***Lot 2 DP 748682
132-138 Killeaton Street, St Ives***

***MP 10_0057 MOD 3 – Modification to reduce
the number of visitor car parking spaces***

Director-General's
Environmental Assessment Report
Section 75W of the
Environmental Planning and Assessment Act 1979

November 2011

CARPARK LEVEL 2 STAGE-2
SCALE 1:200

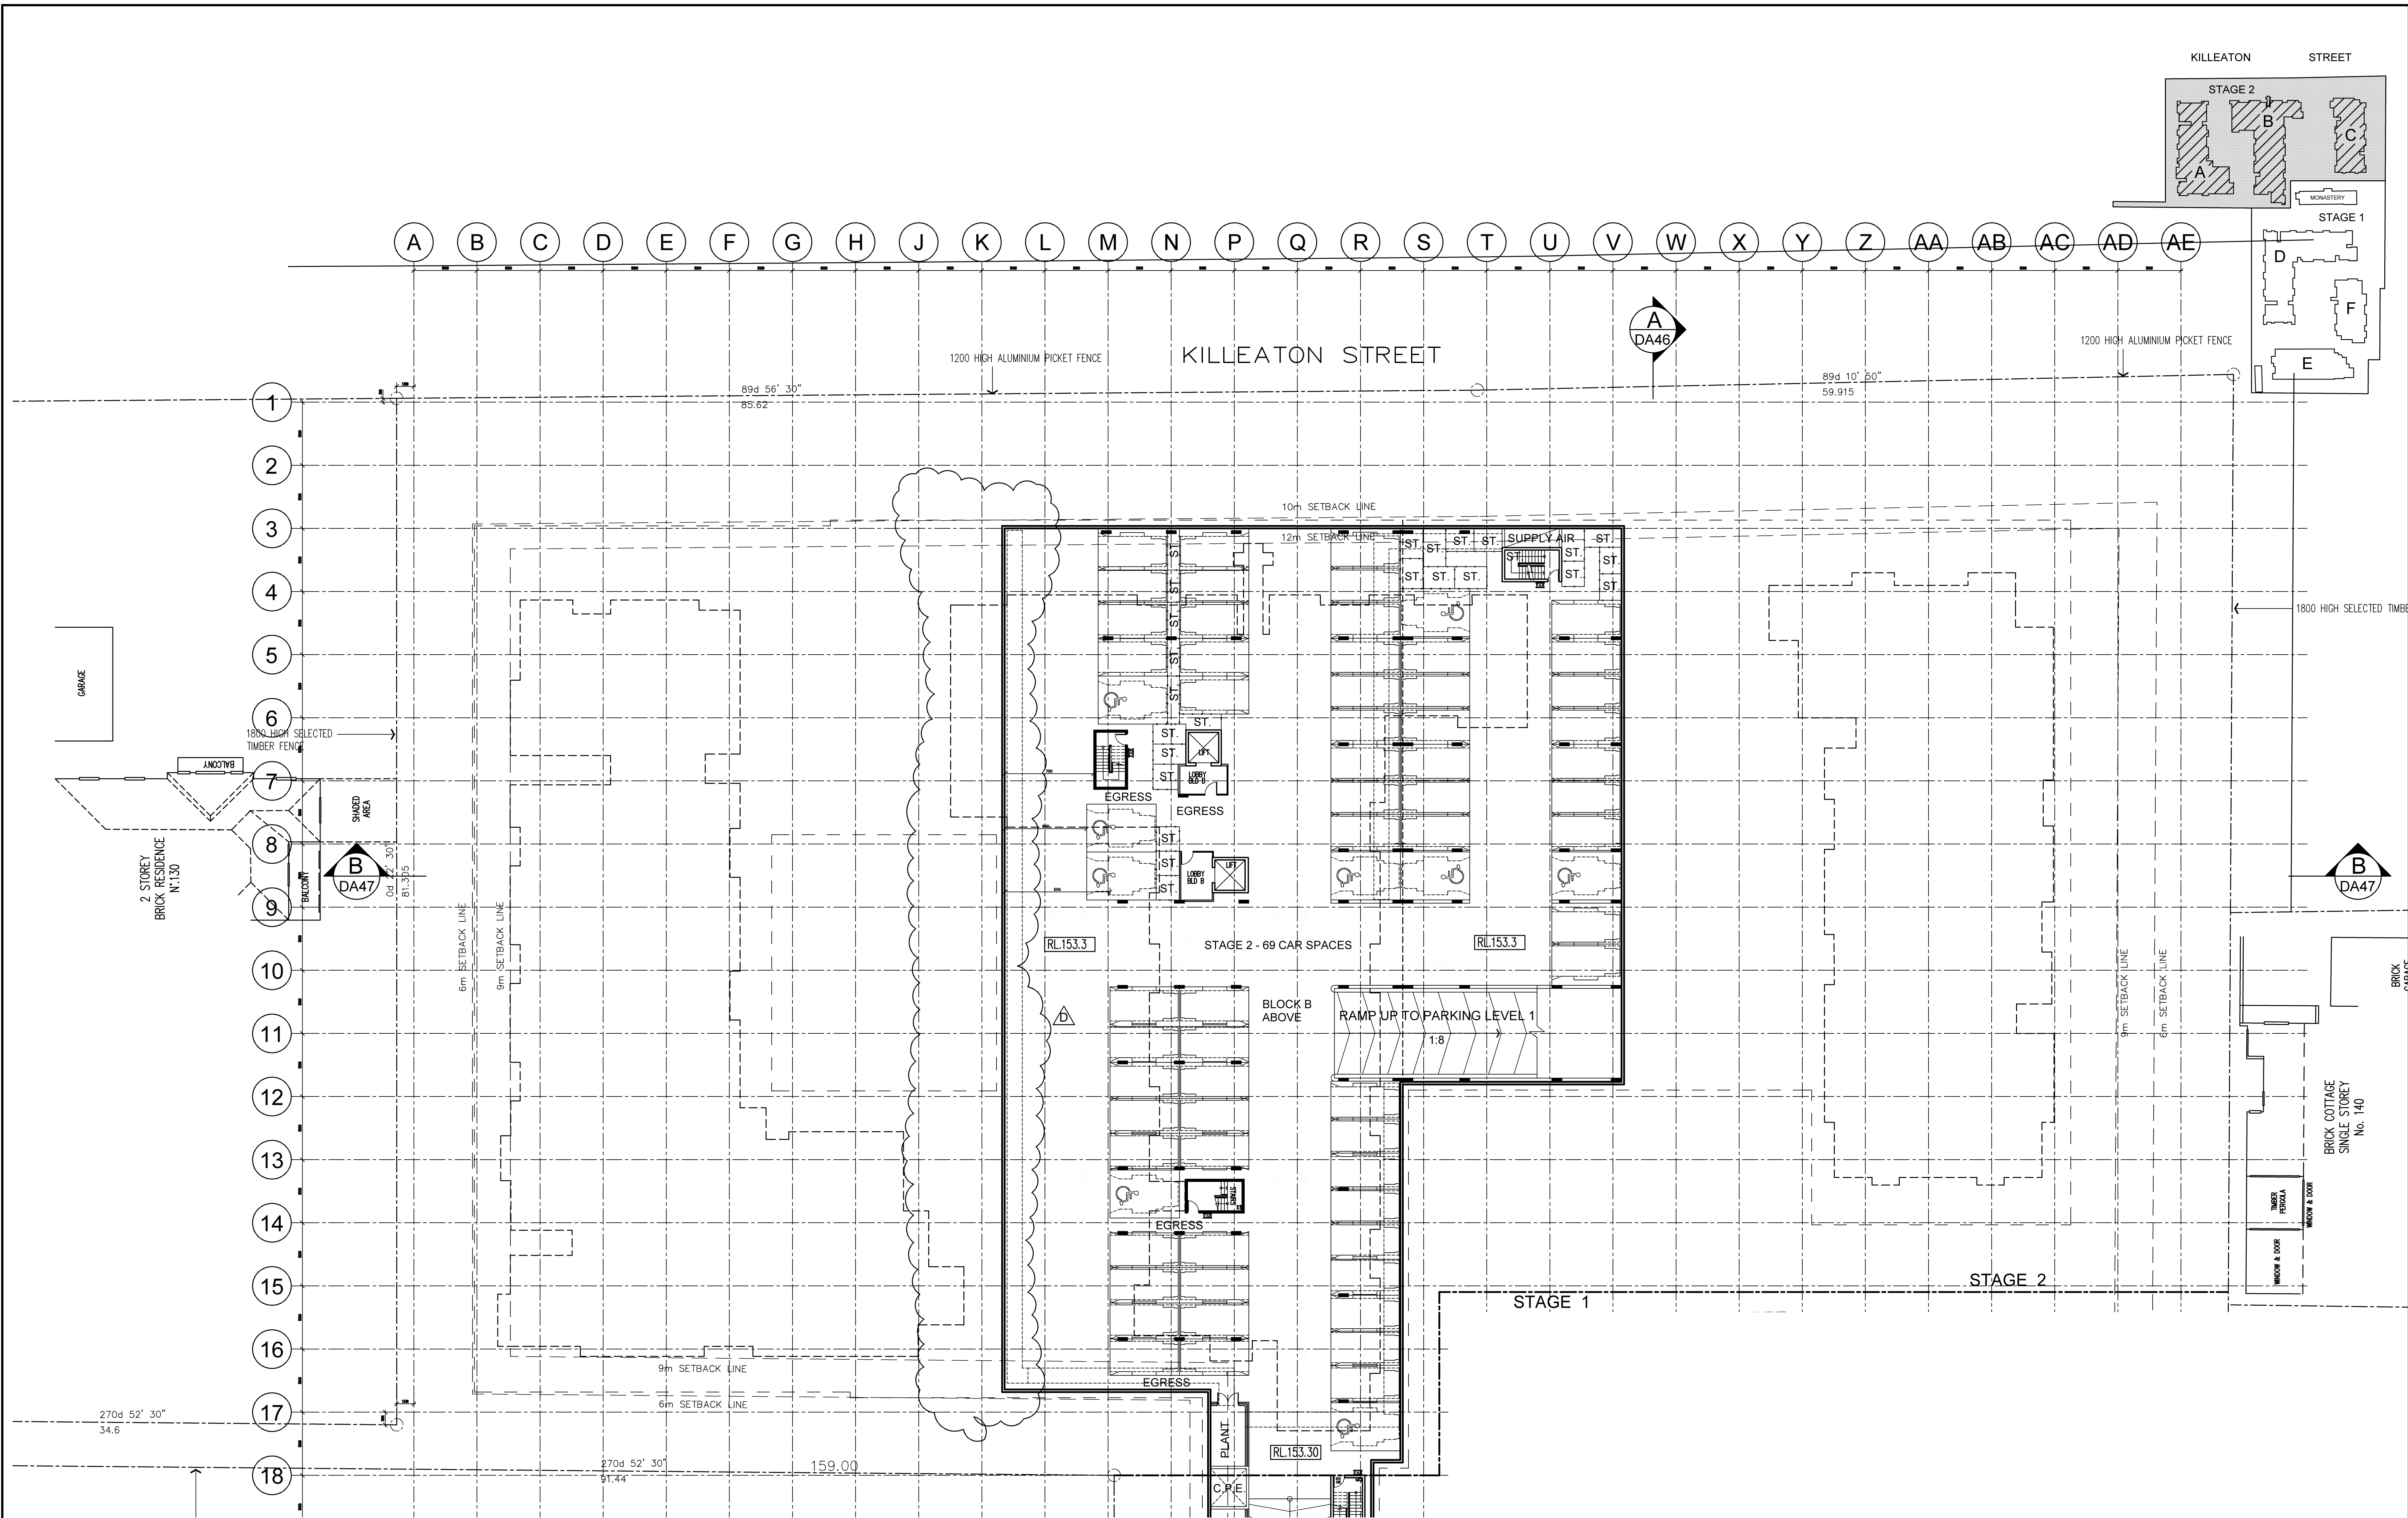
- modify basement level one by reducing the number of car parking spaces provided from 280 to 273 (reduction of seven spaces) by re-arranging spaces in Stage 1 and 2 and modifying the use adjacent the void area below Block A from car parking spaces to storage areas;
- modify basement level two by reducing the number of car parking spaces from 116 spaces to 96 (reduction of 20 spaces) by deleting the car parking spaces provided in Stage 2 along the western basement wall and re-arranging spaces in Stage 1; and
- relocation of storage space.

The modified basement layout is considered to have appropriate regard to the conditions of Approval, including the provision of spaces designated for persons with a disability.
